Planning Application No: 3/2025/0631

Proposal: Proposed two-storey side extension and the demolition of single-storey garage.

Location: 21 Woodside Road Simonstone BB12 7JG

Drawing Title  
Proposed Site and  
Carparking Plan.

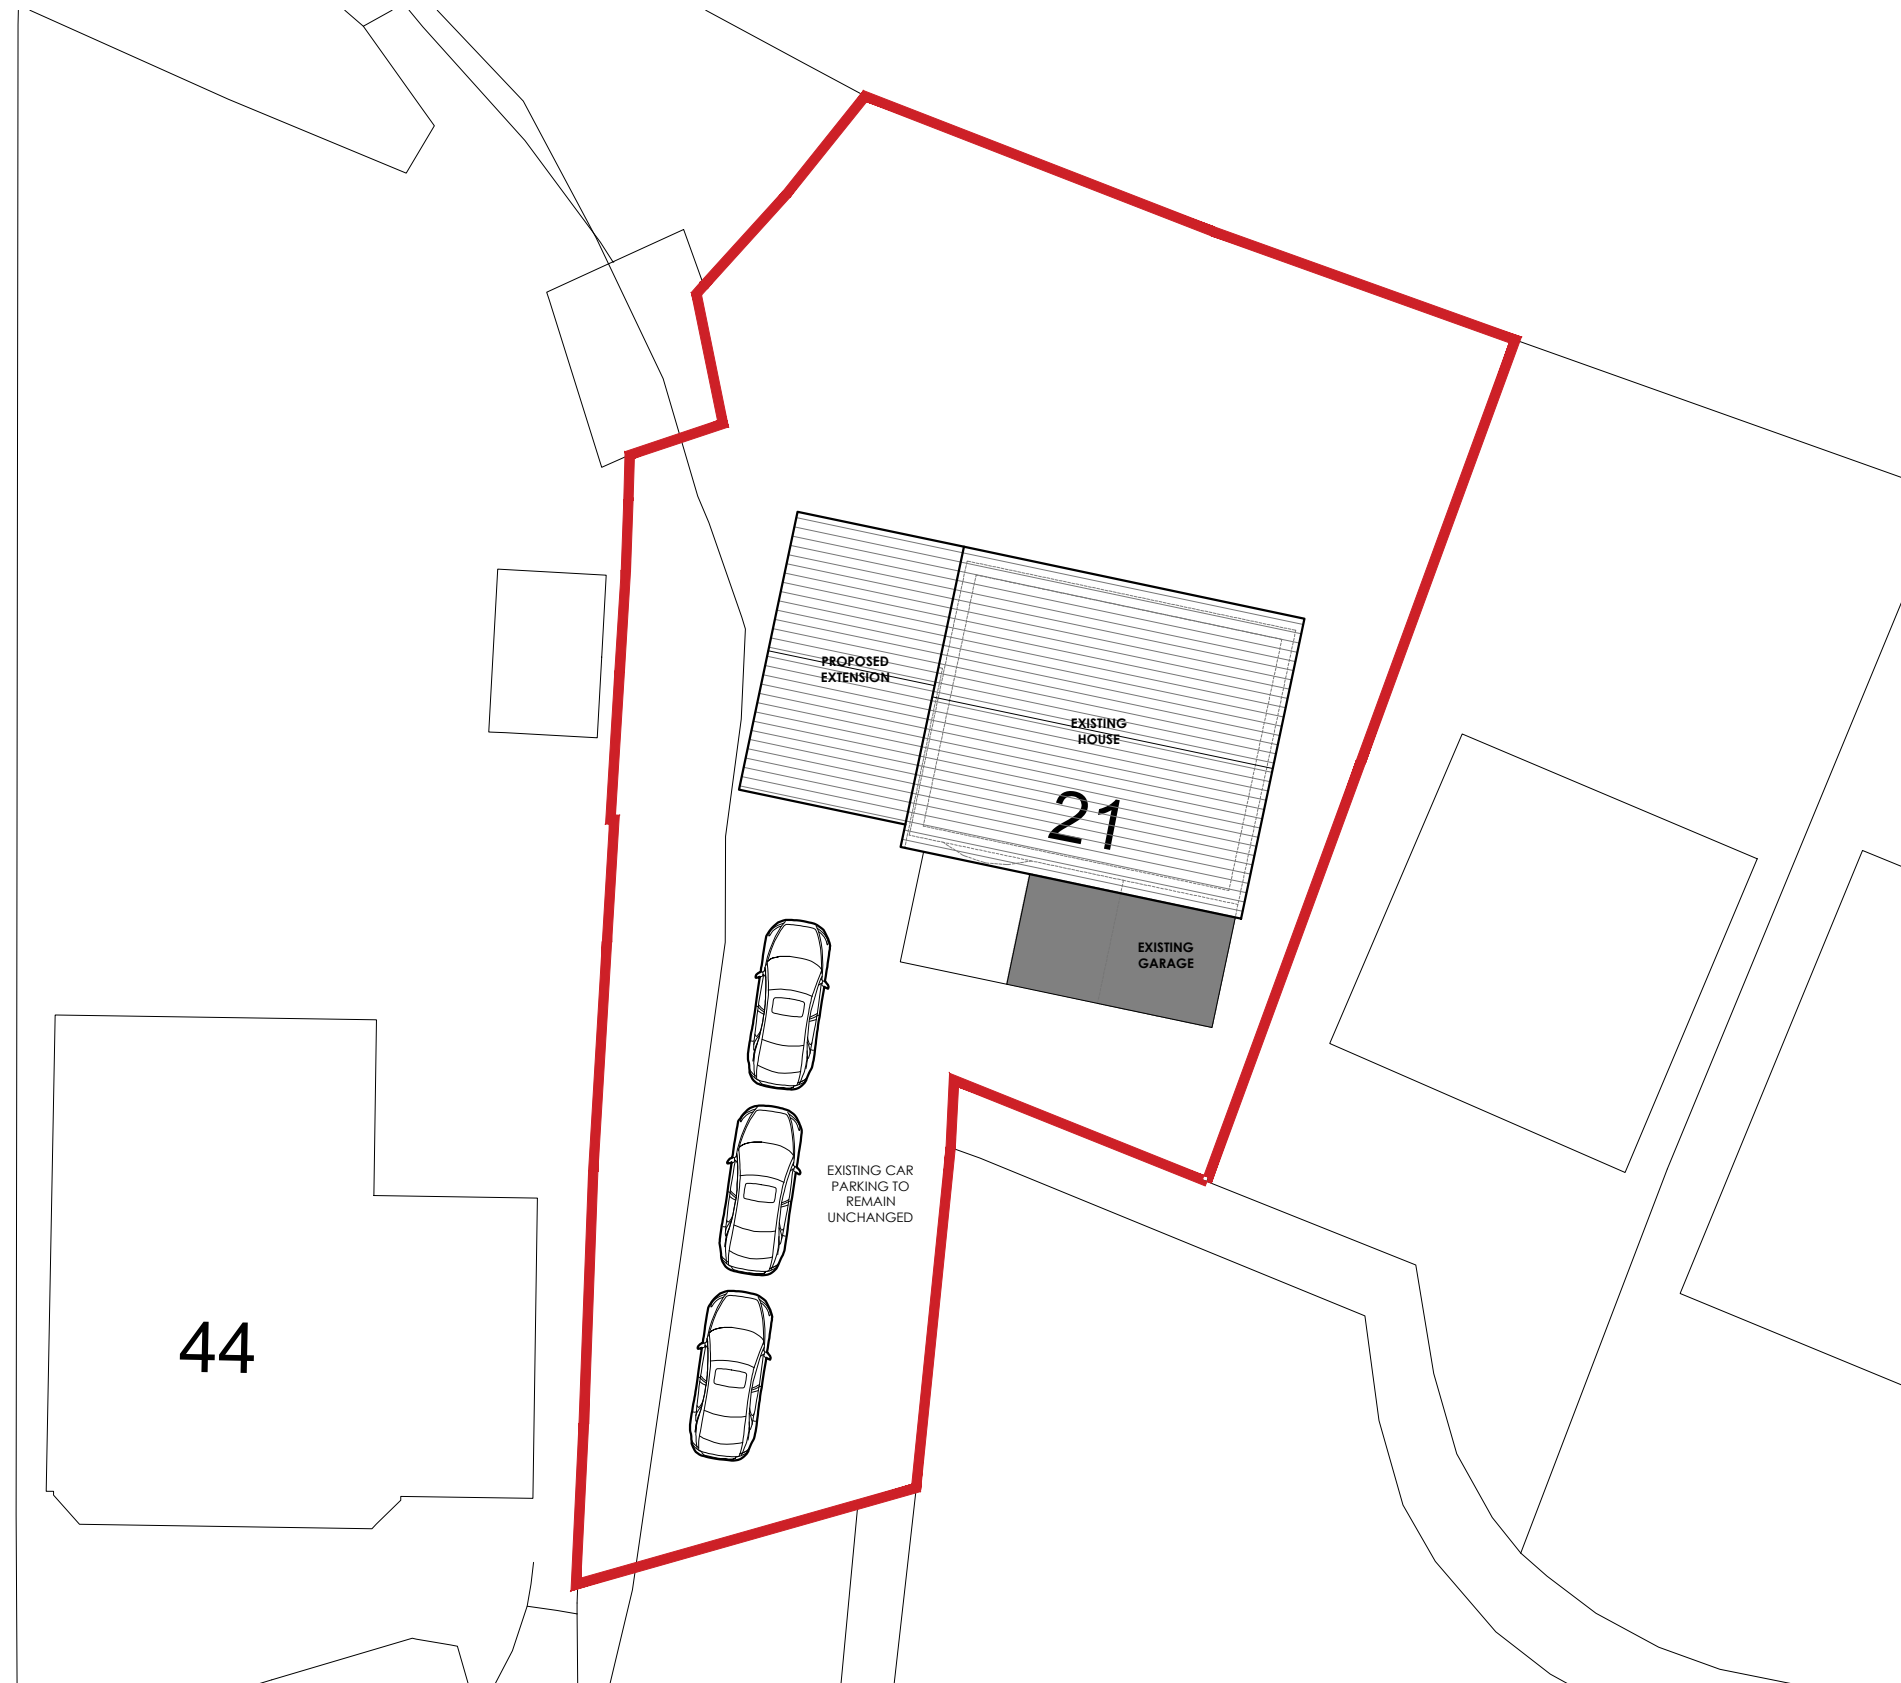
There is no parking plan submitted. A parking plan is required to show 3 parking spaces can be achieved within the curtilage of the property for this proposed 5-bedroom dwelling. Each car parking space should be 2.4m x 4.8m.

Parking on a turning head is not acceptable due to highway safety reasons.
